Date: 08/31/2023

Re: **Damaged I-Joist**
Location: Lot 12 McKay Place (143 Black Creek Dr. (Lillington, NC))
JDS Project No.: RDU2307922
Date of Inspection: 8/31/23

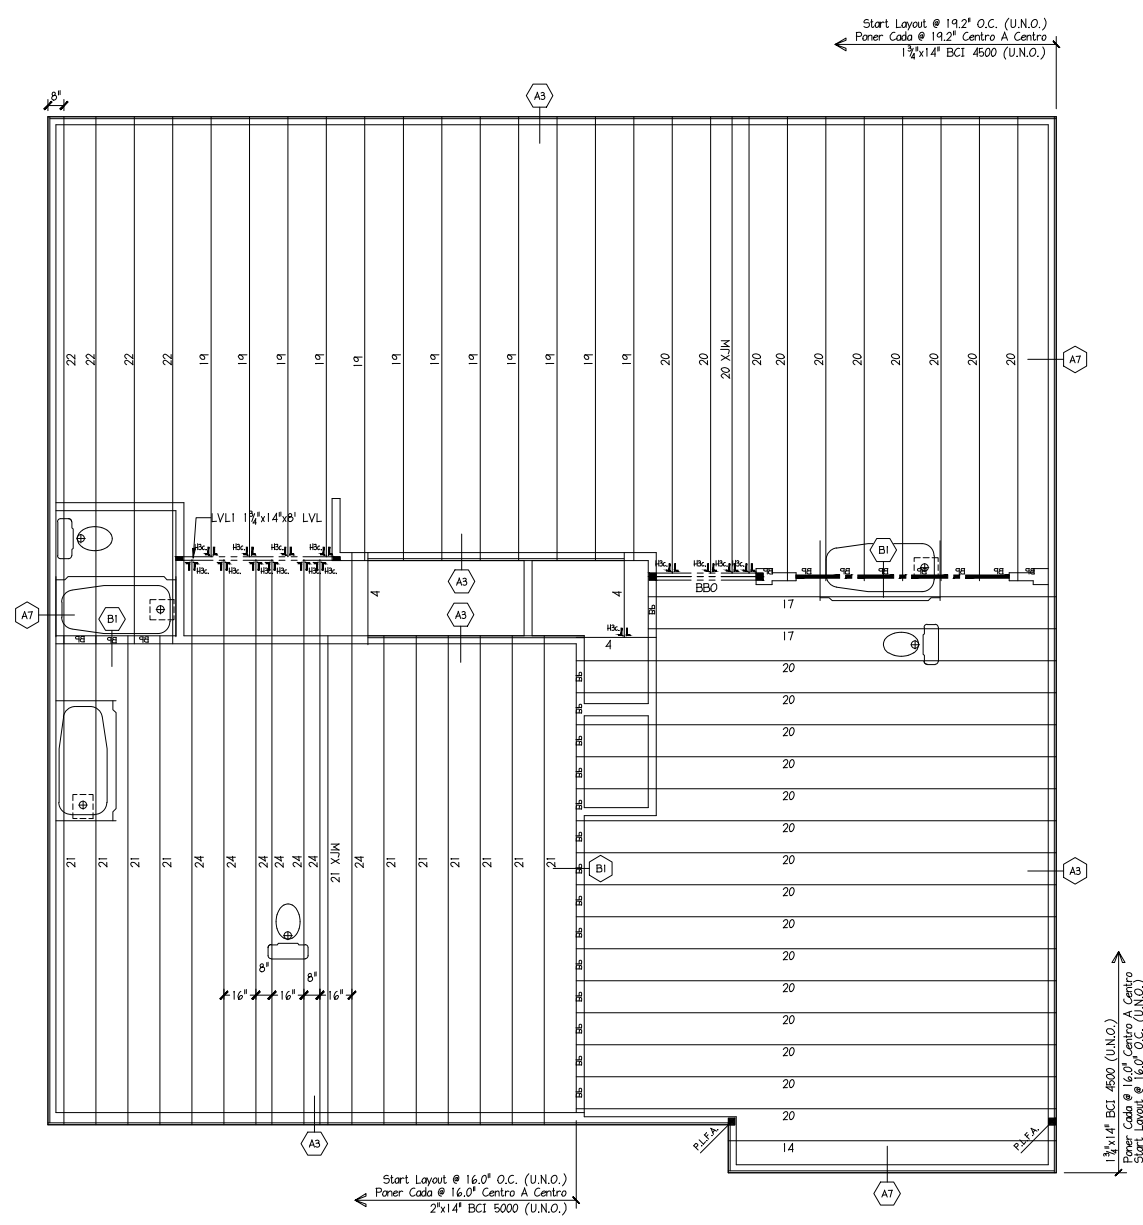
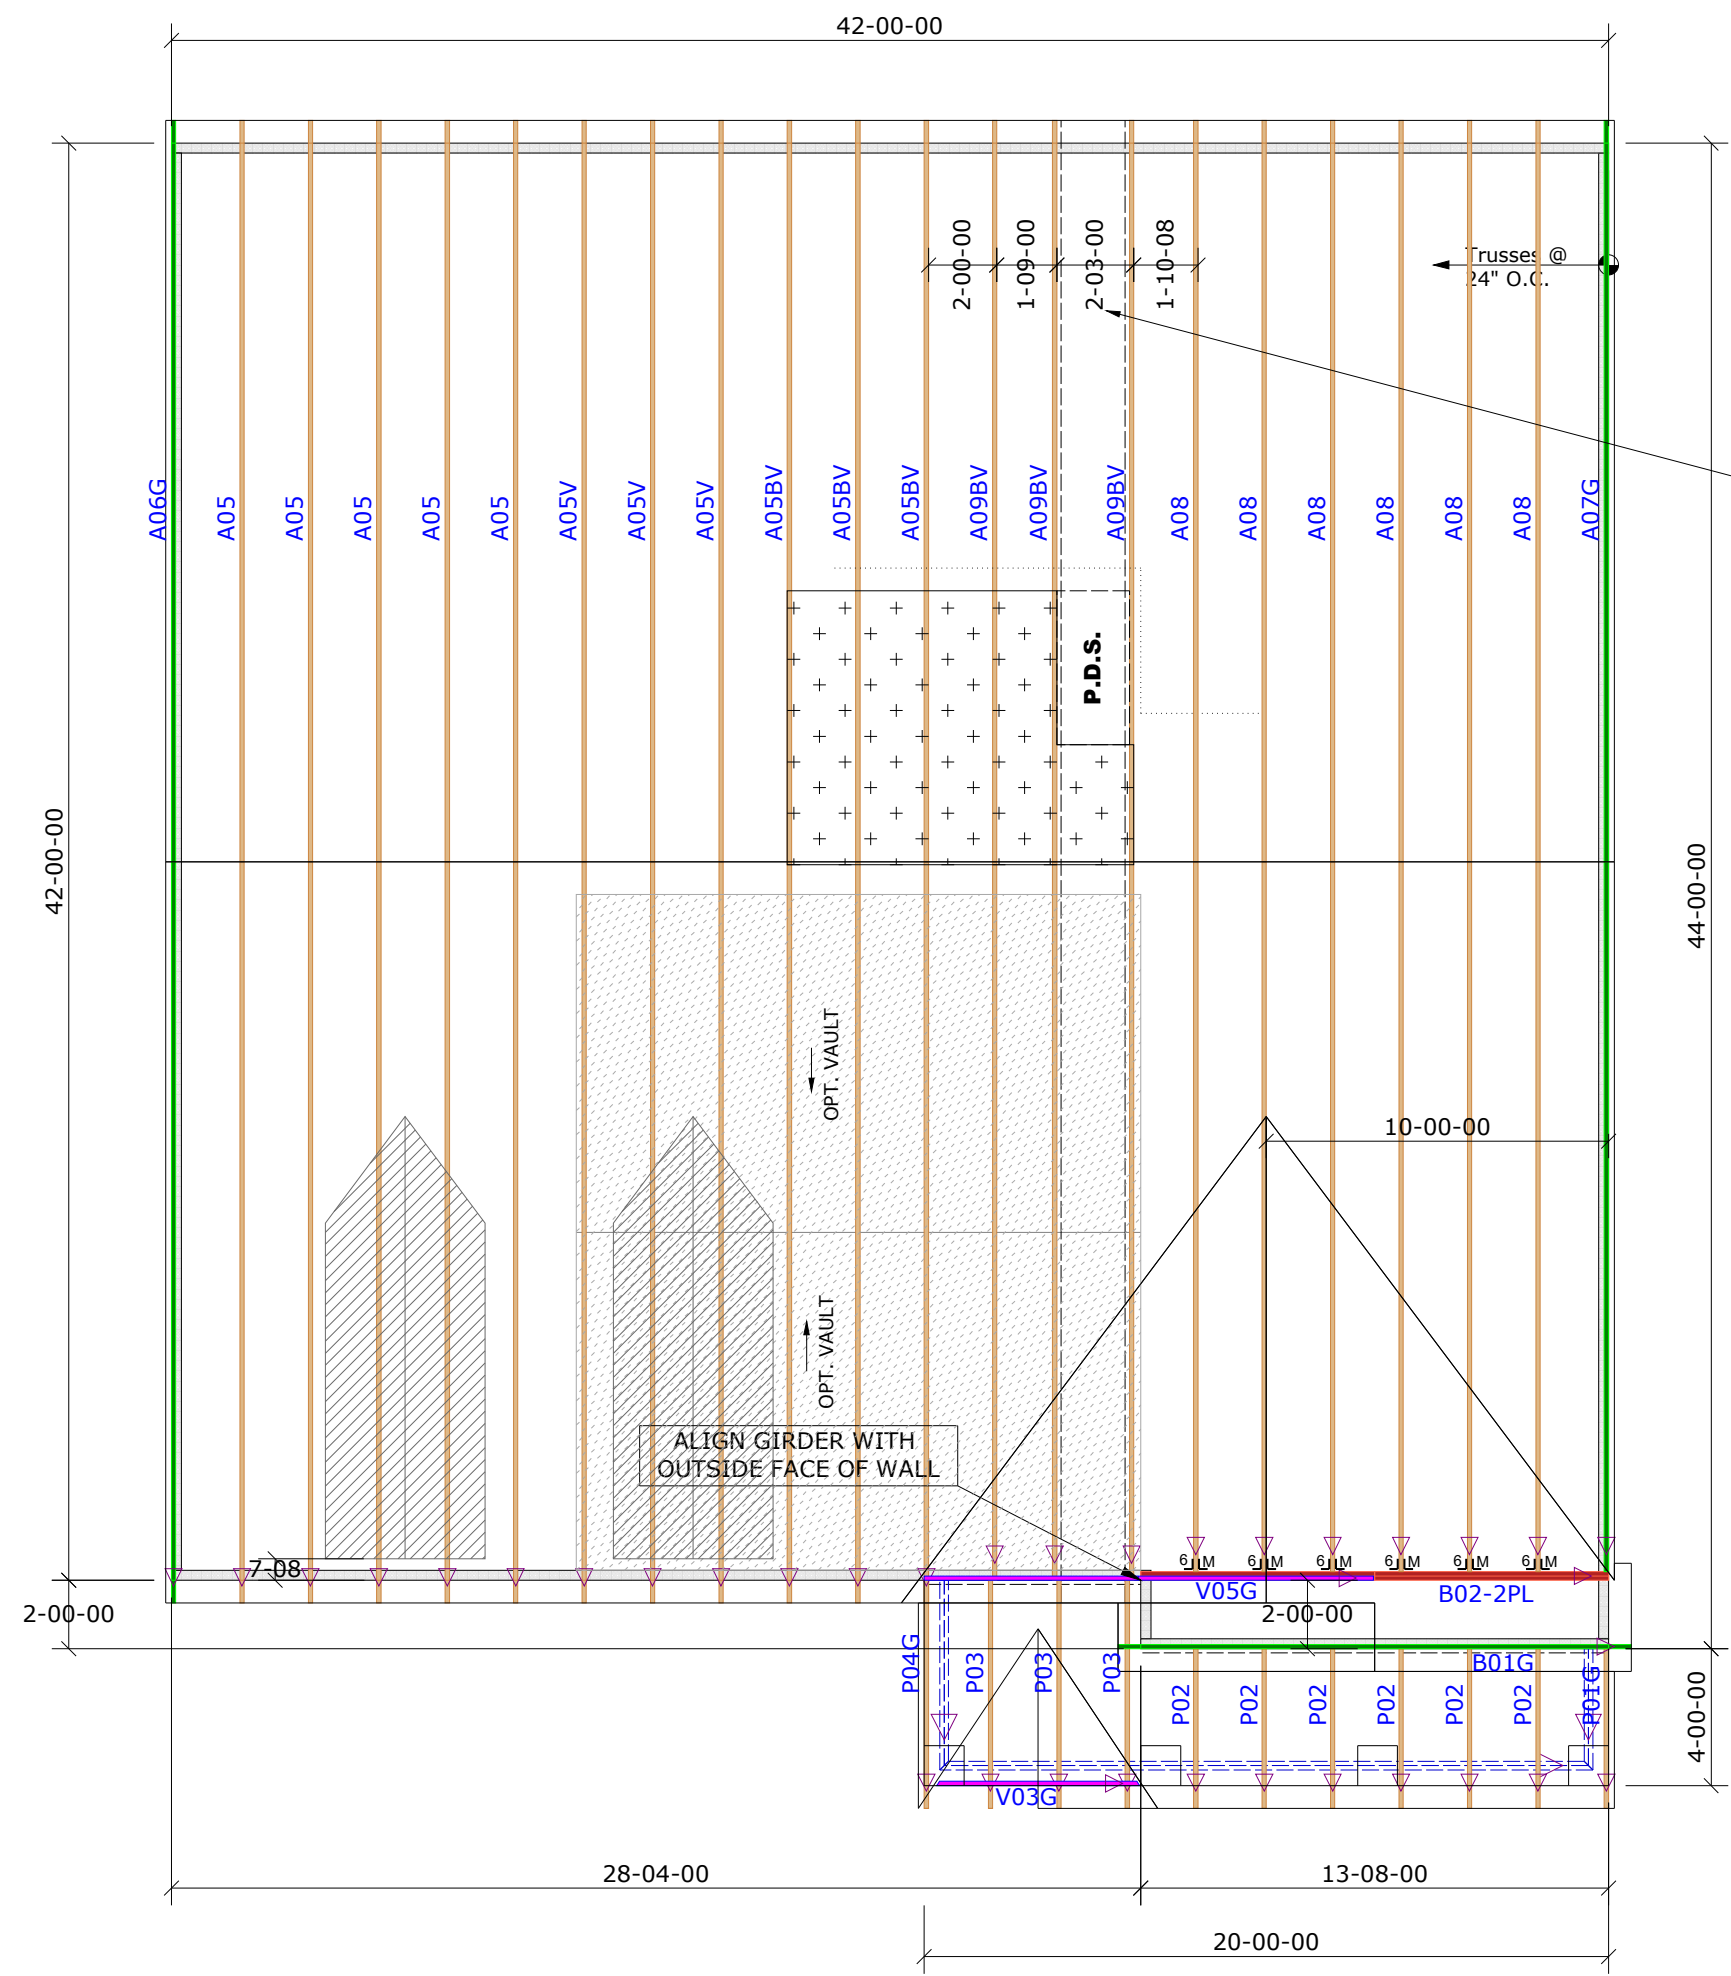
The client has requested evaluation of the 7th from left joist having a damaged top chord starting approximately 5' from the rear bearing end and spanning 12".

Based on our onsite observation and review the contractor shall install (1) 5' by full web depth 7/16" OSB scab on each side centered on the damage. Attach the OSB scabs with construction adhesive and (3) rows of 6d nails 6" O.C. Then install (1) 5' 2x4 scab on each side centered on the damage and flush with the top of the top flange. Attach 2x4 scabs with (2) rows of 10d nails 6" O.C.
